Your Ref:  
To named Interested Parties  
Our Ref: EN010072  
Date: 21 December 2016

**Application by Snowdonia Pumped Hydro Limited ("the Applicant") for an  
Order Granting Development Consent for the Glyn Rhonwy Pumped Storage  
(Generating Station)**

**REQUEST FOR COMMENTS FROM THE APPLICANT, NATURAL RESOURCES  
WALES, THE MINISTRY OF DEFENCE, GWYNEDD COUNCIL, GWYNEDD  
ARCHAEOLOGICAL PLANNING SERVICE AND CADW**

### Indicative Elevations & Section of Penstock Configuration (Revision 1)

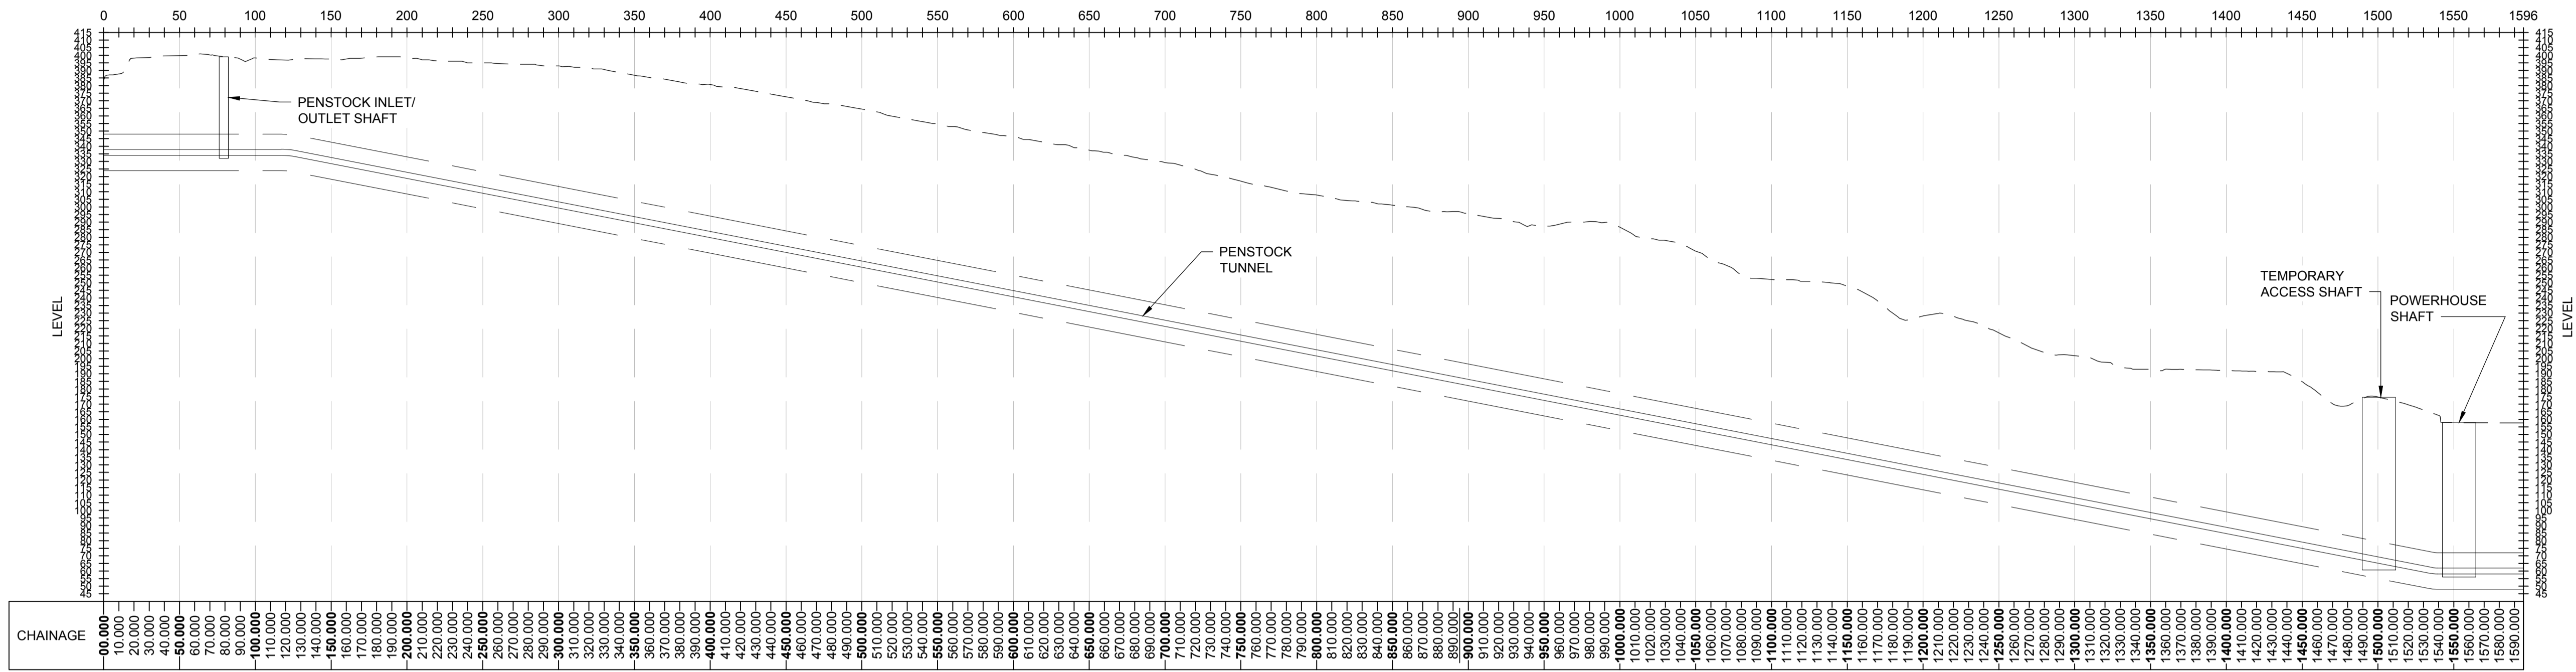
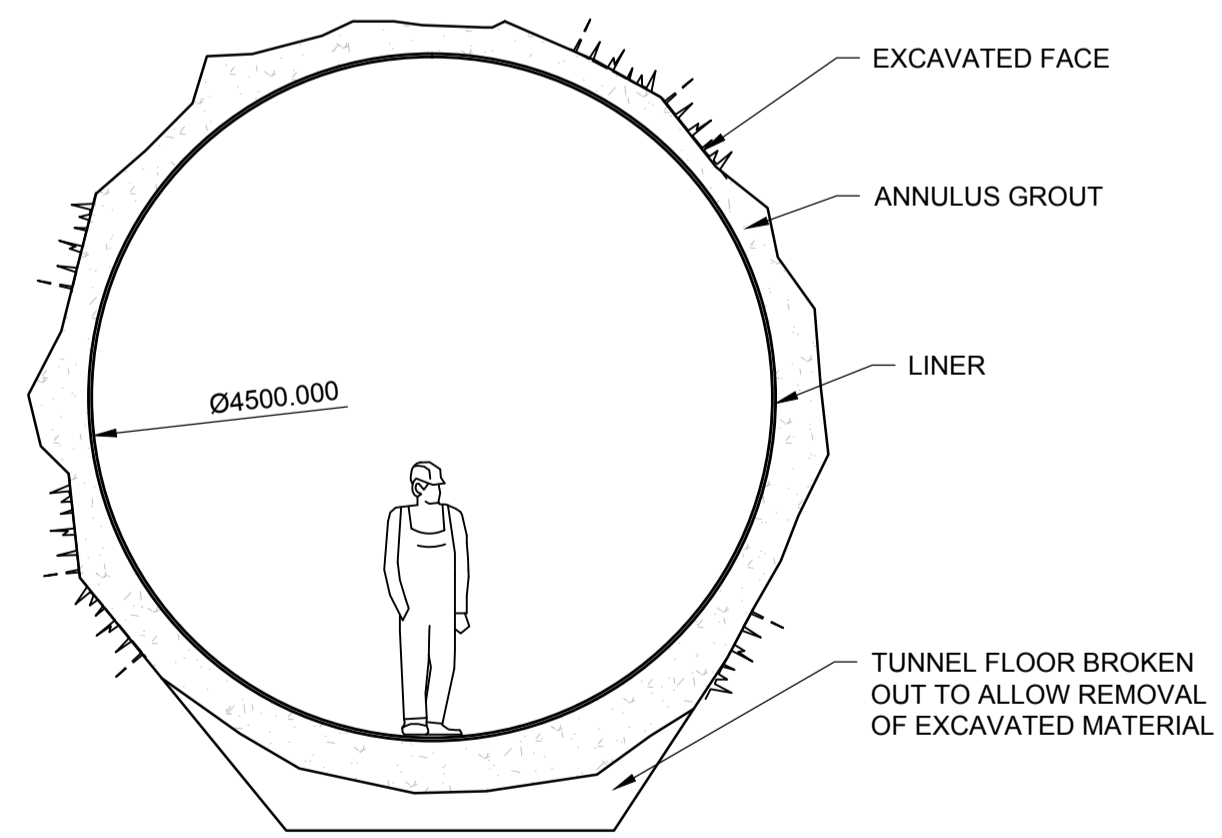
(1) *"The CoCP required under sub-paragraph (1) must include provision to ensure that the underground excavation of Works 2 is to progress in the direction from Work 3A to Work 1A.*

- (i) secure that underground excavation of the penstock (Work 2) would progress in the direction from the lower reservoir (Work 3A) towards the upper reservoir (Work 1A) - '1' above;
- (ii) secure limits to the movements of heavy goods vehicles on access routes during construction; and
- (iii) secure pre-commencement surveys for floating water plantain in the vicinity of the spillway infrastructure in Llyn Padarn and for tree-roosting bats.
